Application No: AB/114/20/PD
Site Address: Riverside House 2 Fitzalan Road Arundel BN18 9JS
Description of works: Notification for Prior Approval under Schedule 2 Part 1 Class AA for a additional 2 storeys on existing dwelling house.

Thank you for your internet representation made on 30th November 2020 which has been recorded as an objection with the comments as follows:

Drawing Title:
PROPOSED ELEVATIONS

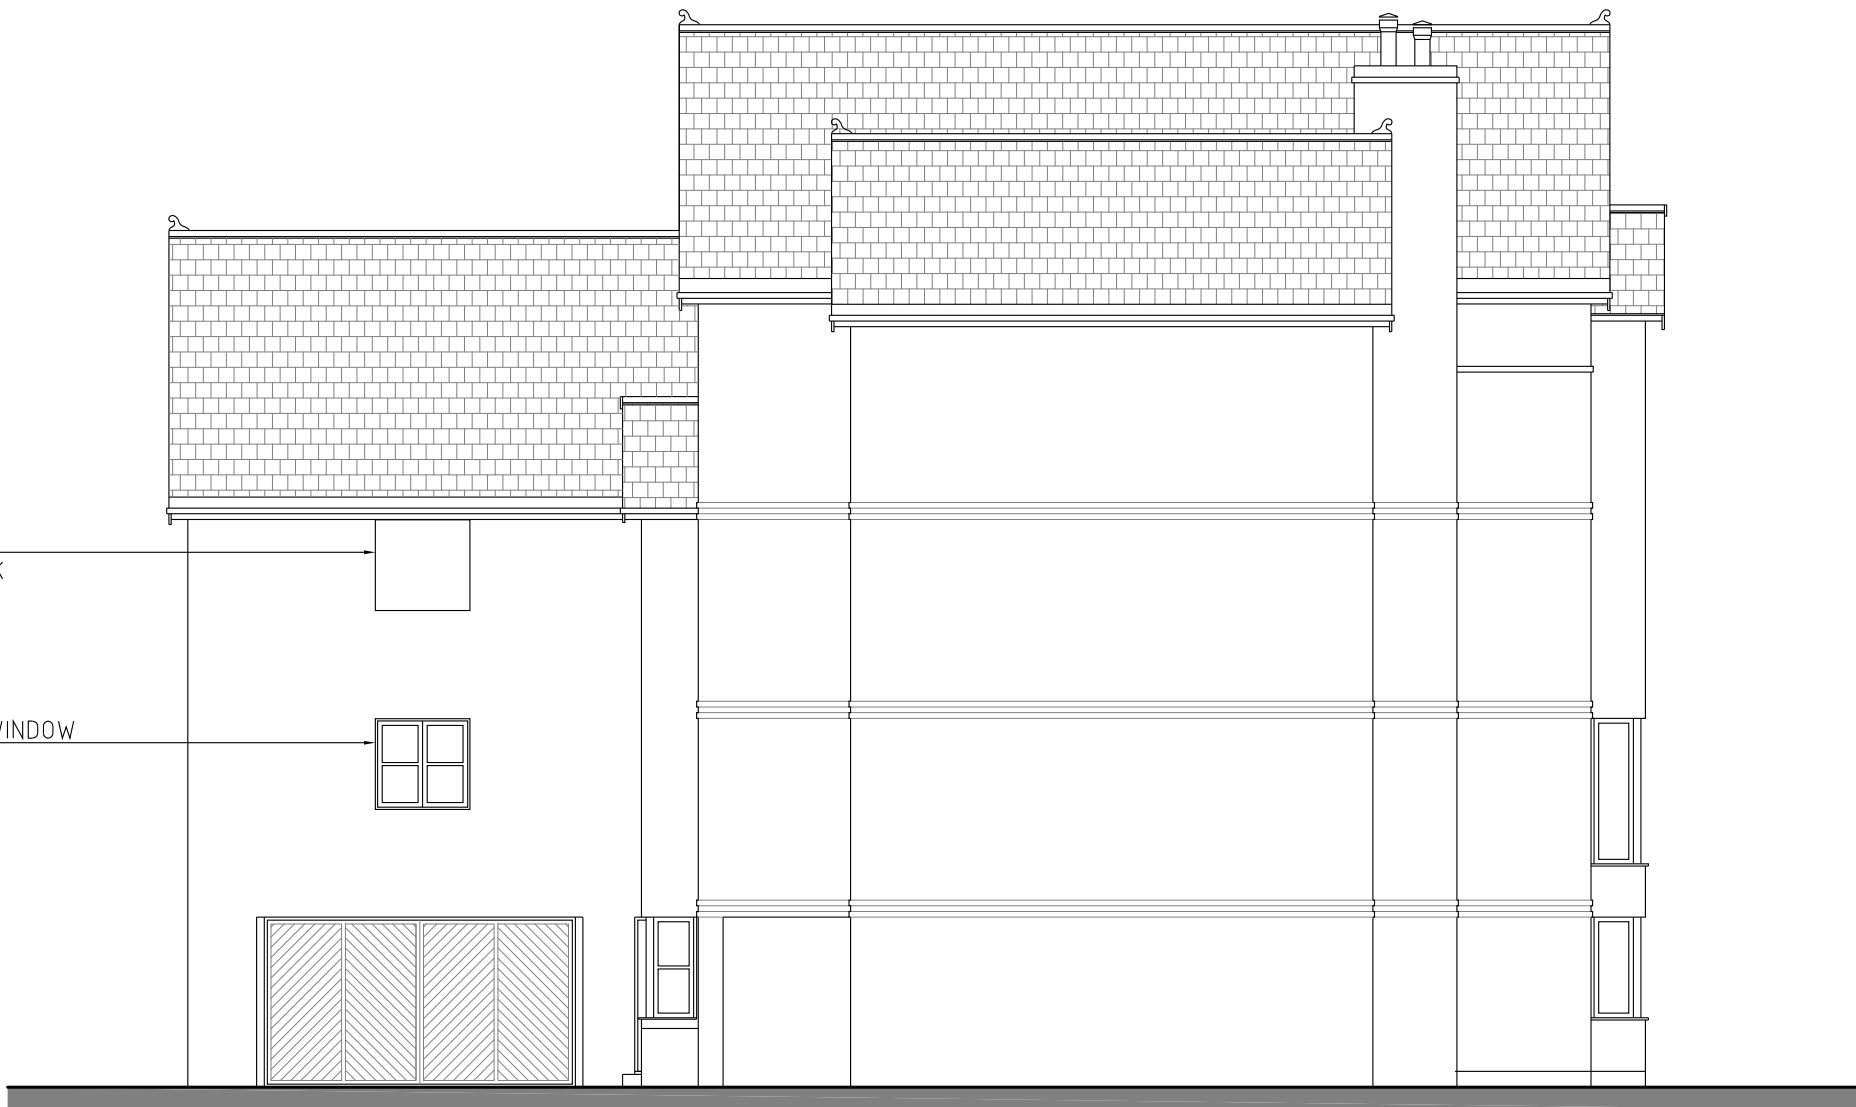
- there is no connection between the core of the house and the top three floors of the extension above the Home Office;
- the height of the extended dwelling will be disadvantageous to the Council's planned housing development of the Blastreat property and the blank wall of the south-eastern elevation of the Home Office and above situated close to the road is particularly insensitive;
